Subject: AB/23/21/L & AB/22/21/HH

17 Maltravers Street Arundel BN18 9AP

(Listed building consent for) New slate roofed porch to rear door, new back door to replace existing rotten door, new insulated roof access window to provide maintenance access to butterfly roof valley, replace broken slates and refix slipped slates, various timber repairs to windows to

Proposed Works at: 17 Maltravers St. ARUNDEL BN18 9AP	
Rear Elevation Existing	12
1:50 Feb'21

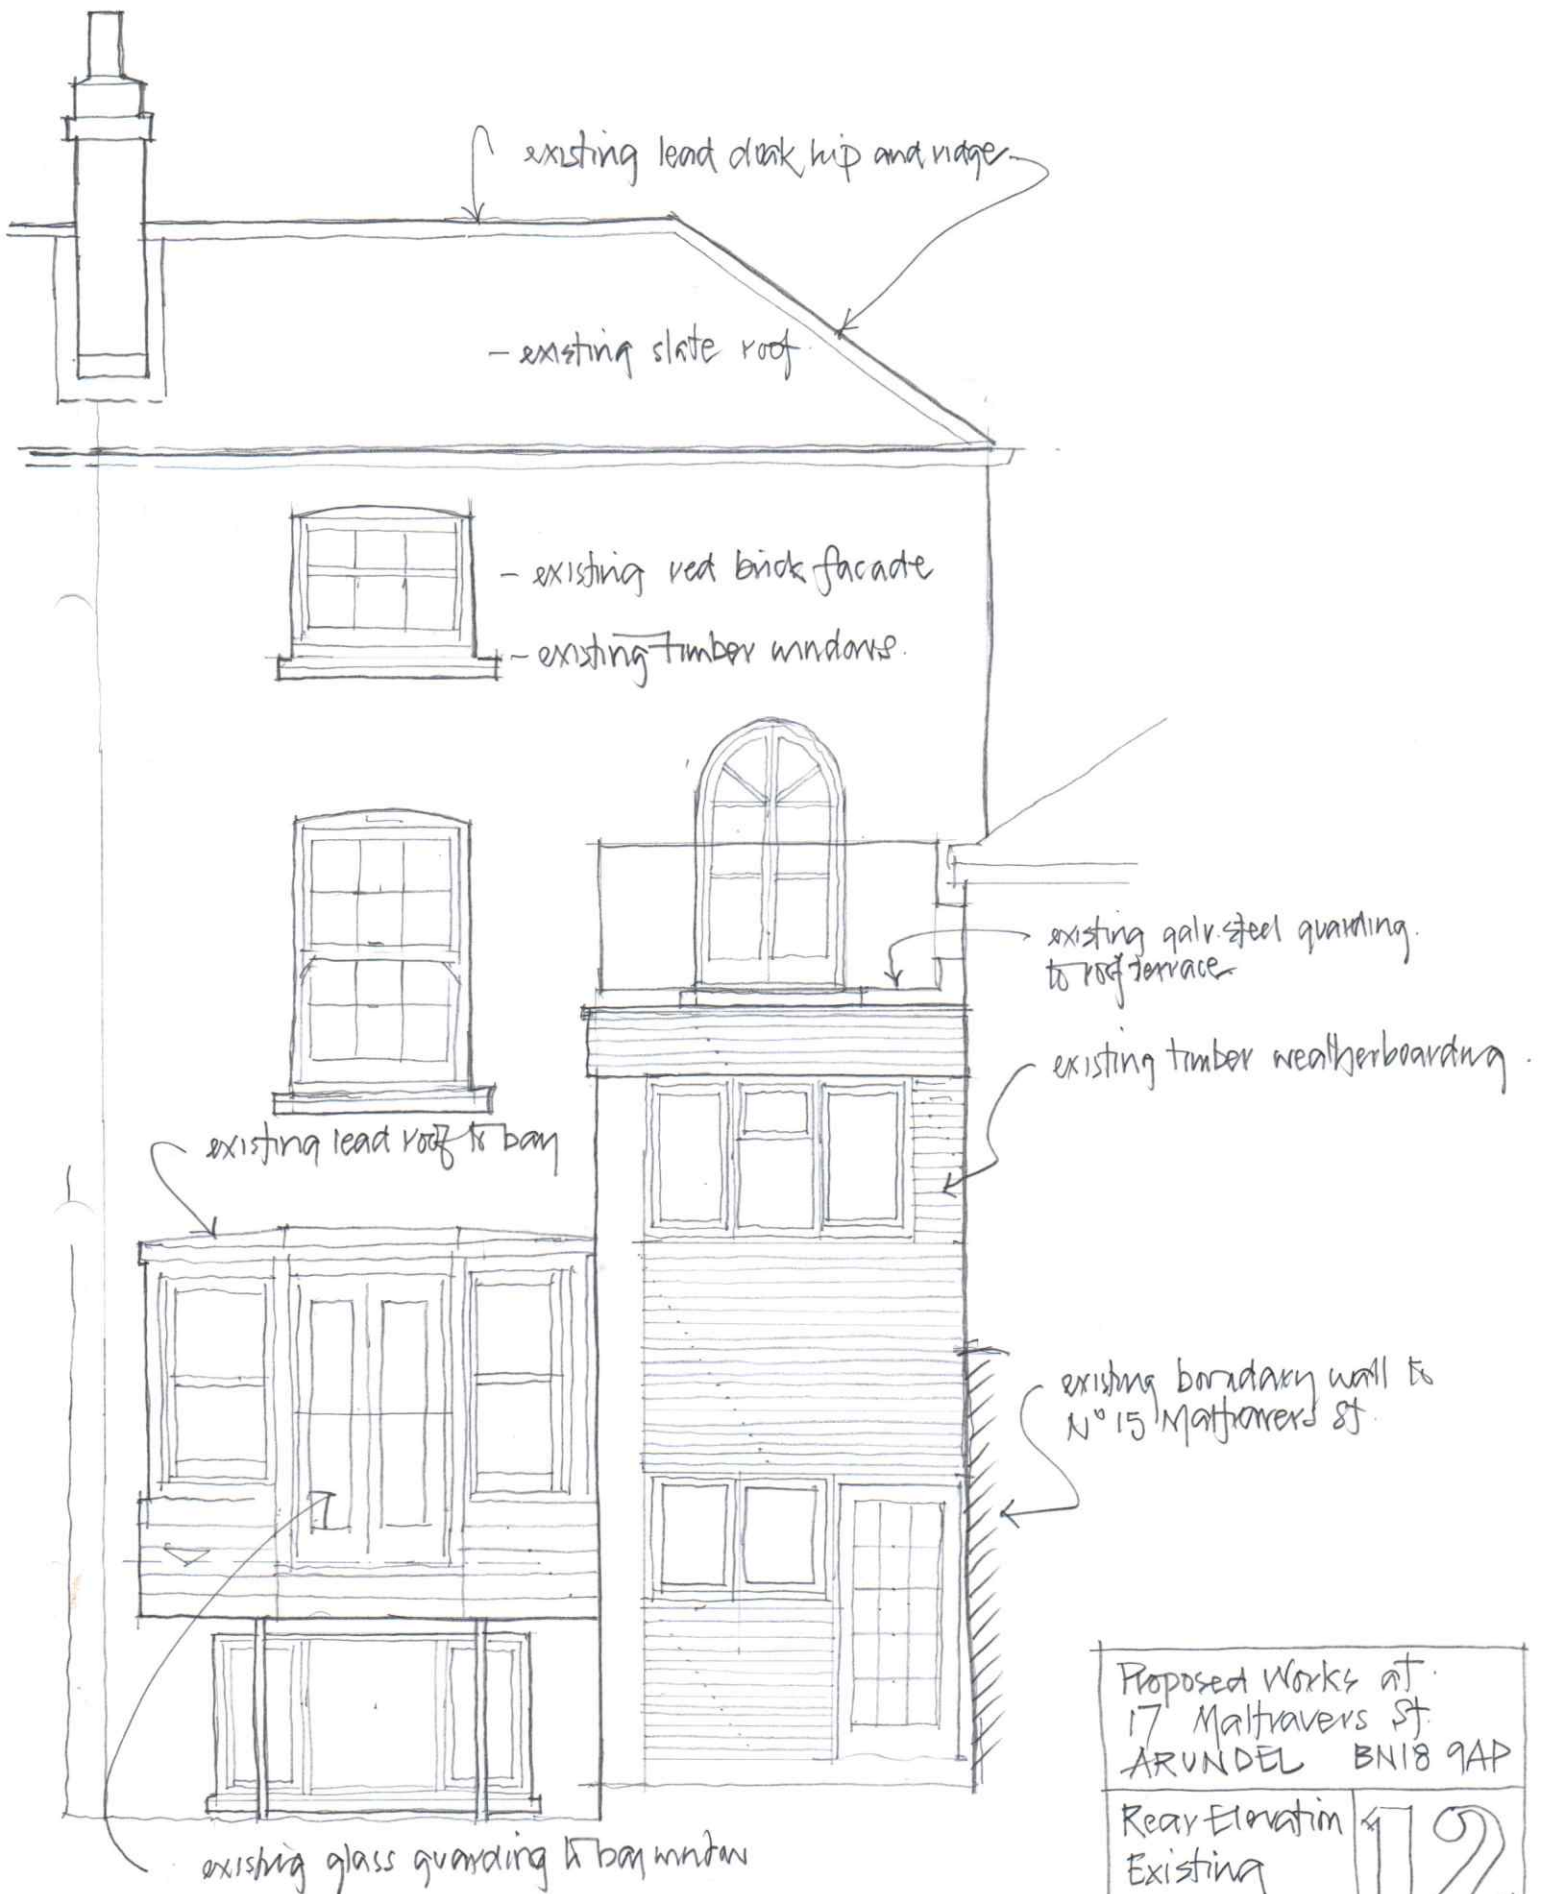
The rear porch is of a scale as to not impact upon the rear elevation and would to some extent help to shield the more recent extension. Appropriate materials are proposed and should reflect those already at the property. I note from the proposed elevation that a new timber door is also required. Whilst this looks to be acceptable, it would help to have further information regarding its appearance, glazing and treatment.

Proposed Works at 17 Malttravers St ARUNDEL BN18 9AP	
Roof Plan Existing.	15
1:50 Feb'21

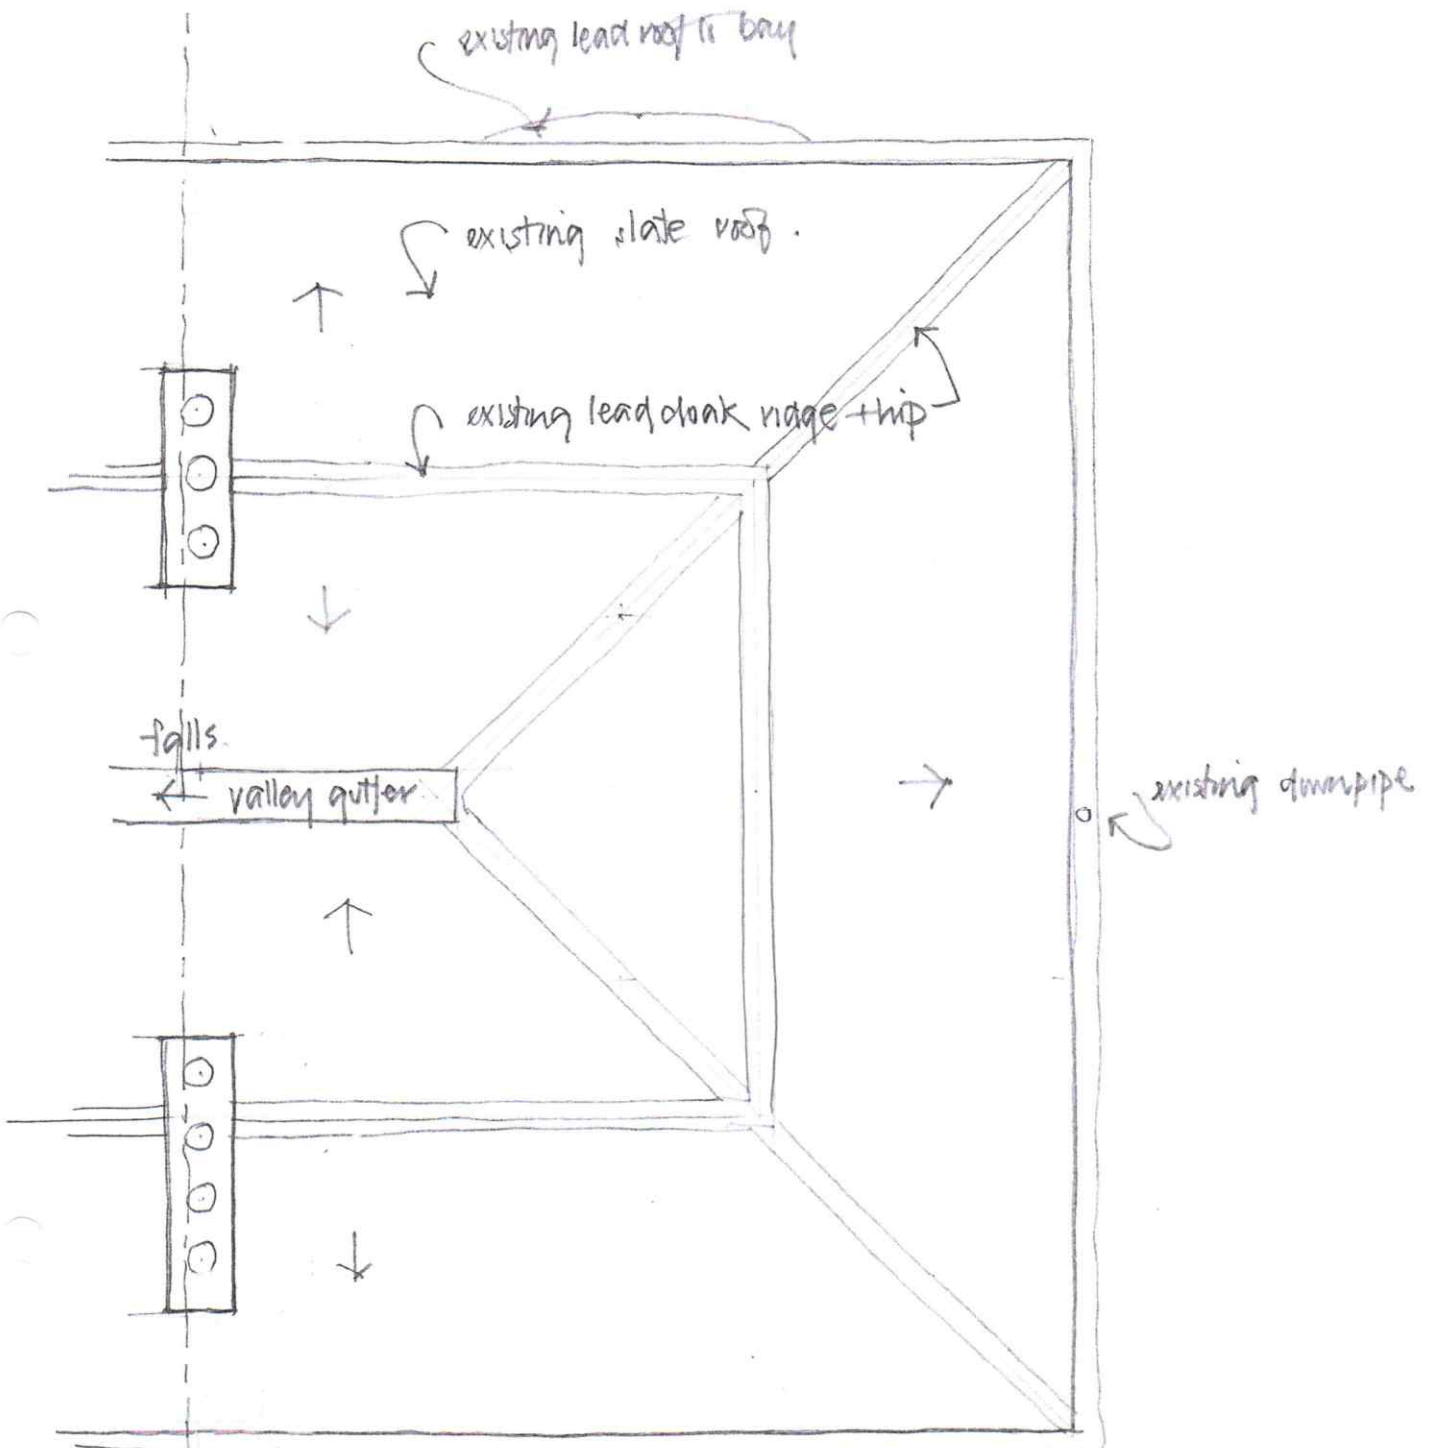
Whilst the proposal appears to include a considerable amount of work, some of the elements are works of repair which will allow the building to remain in a good condition. Whilst this is positive, I would want to be assured that the repointing of the chimney would be undertaken in a sympathetic way so as to not damage any historic fabric. As part of this works should not remove existing pointing using electronic tools and the replacement materials should match the existing in composition and appearance etc. The proposed Velux should also be of conservation standard.

Proposed Works at 17 Maltravers St. ARUNDEL BN18 9AP	
Lower Ground. Proposed	7 B
1:50 Feb'21

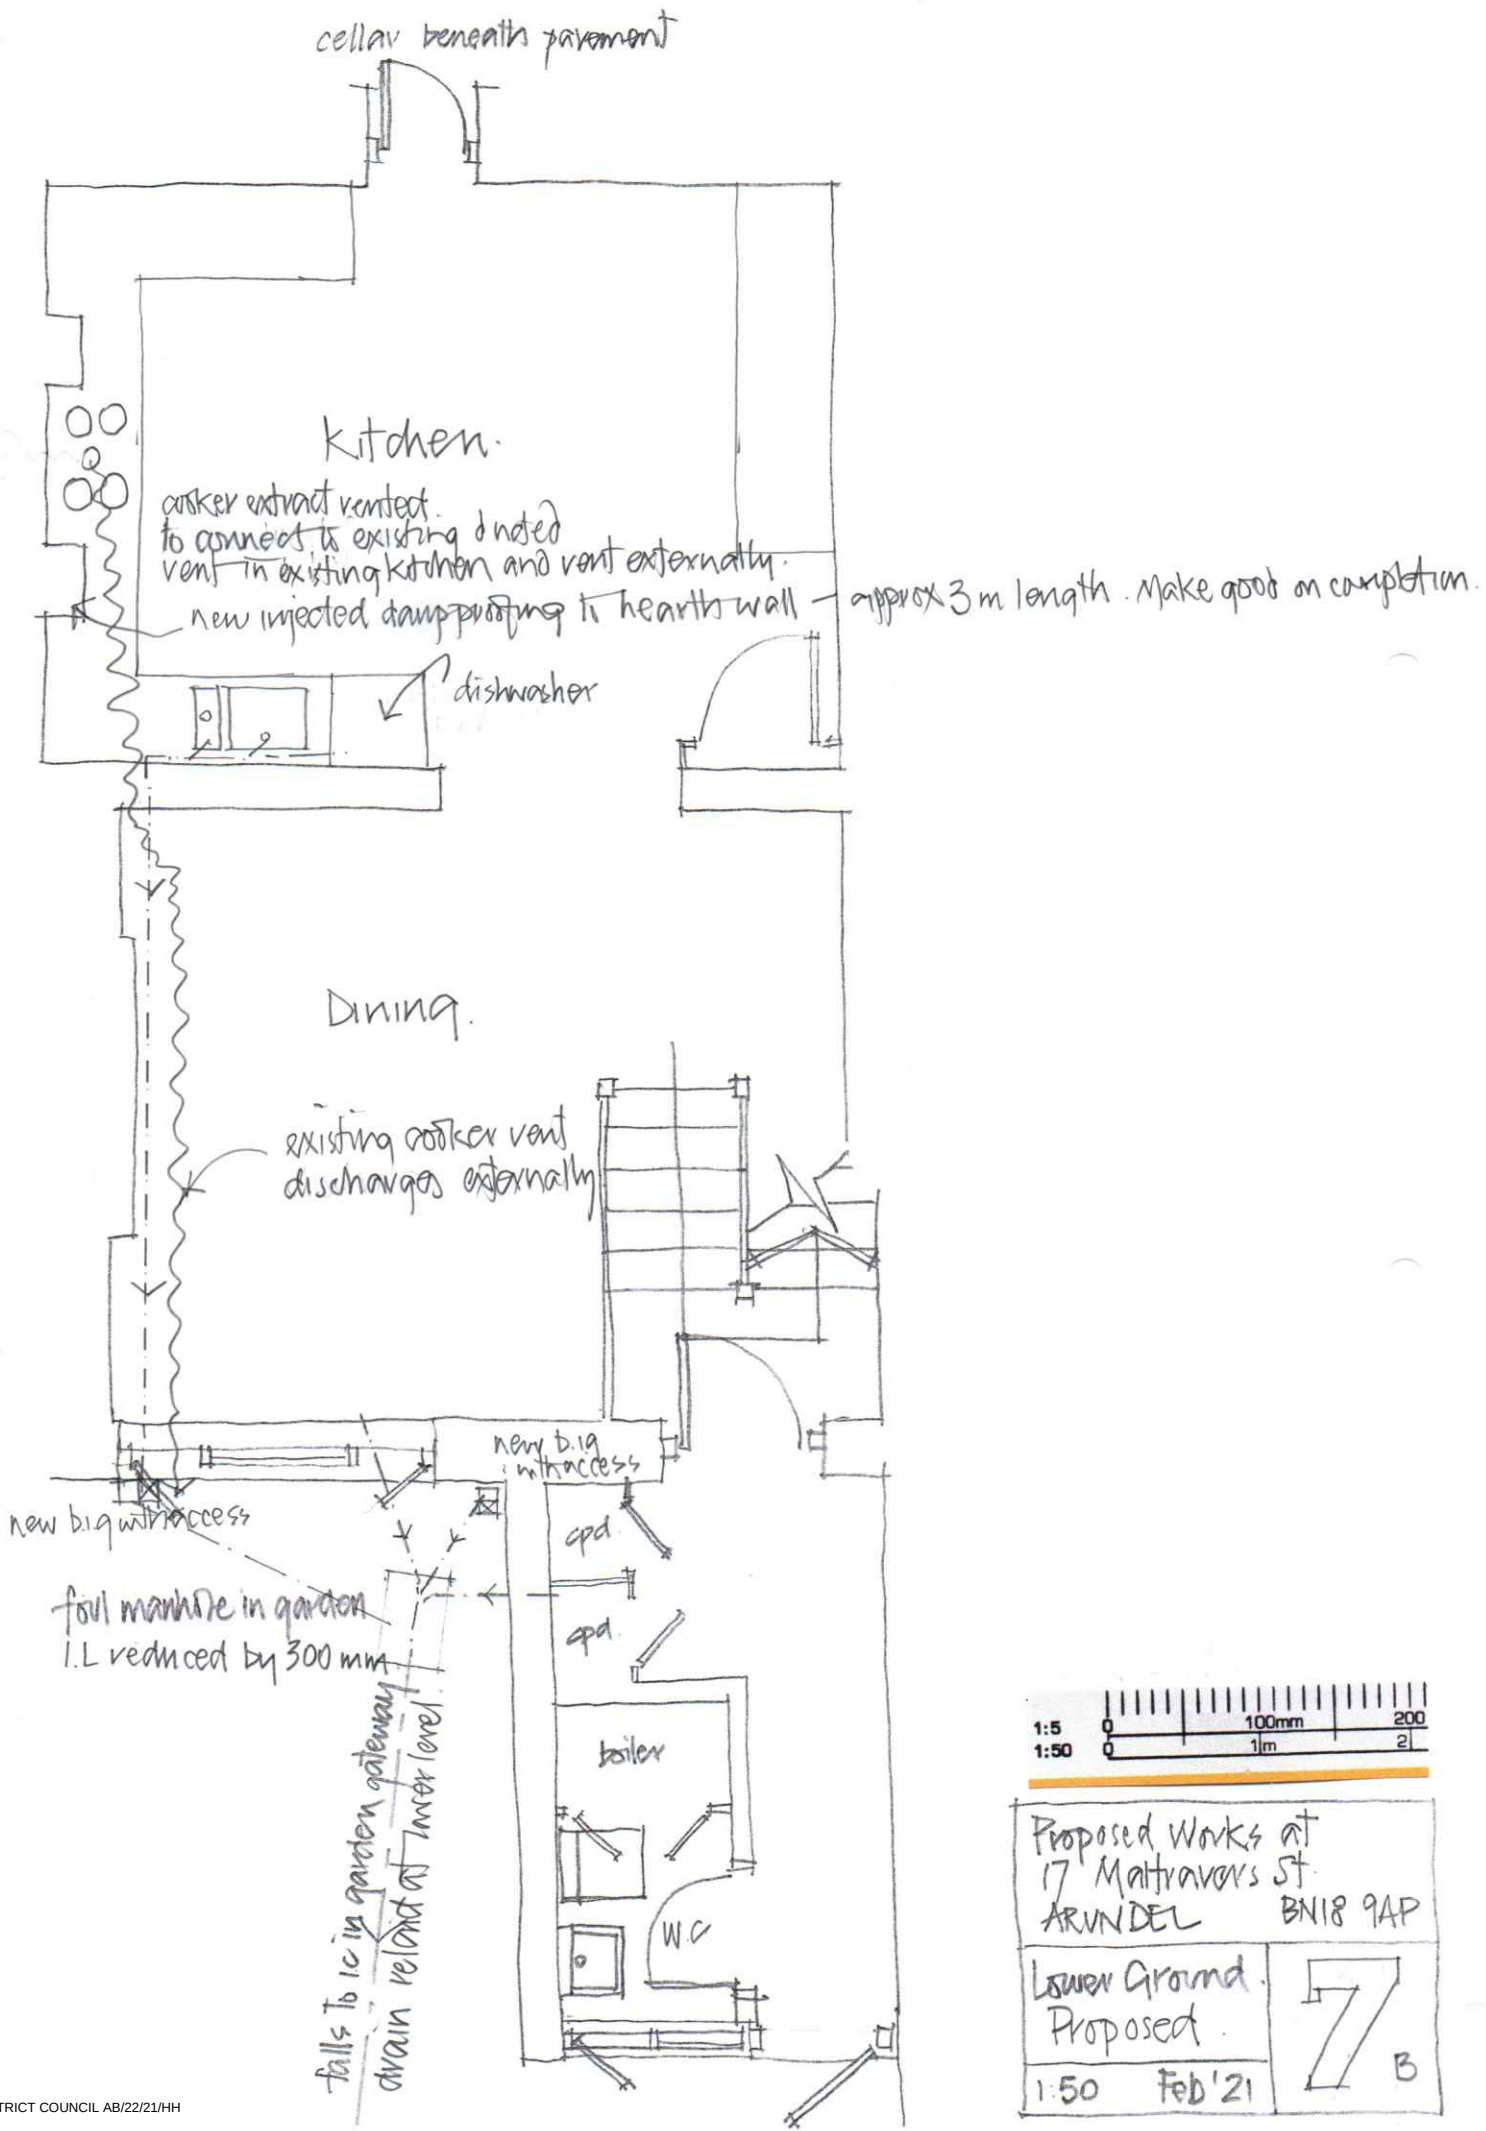
The rearrangement of the lower ground floor to swap the existing kitchen space with the dining room will not cause harm. I note that the intention is to enclose the drainage and air vent pipes for the kitchen so as to not compromise the rear room. This is positive. I should point out that whilst a proposed floor plan can be seen, I am unable to find an existing one for the lower ground floor. However, the section information was of assistance.
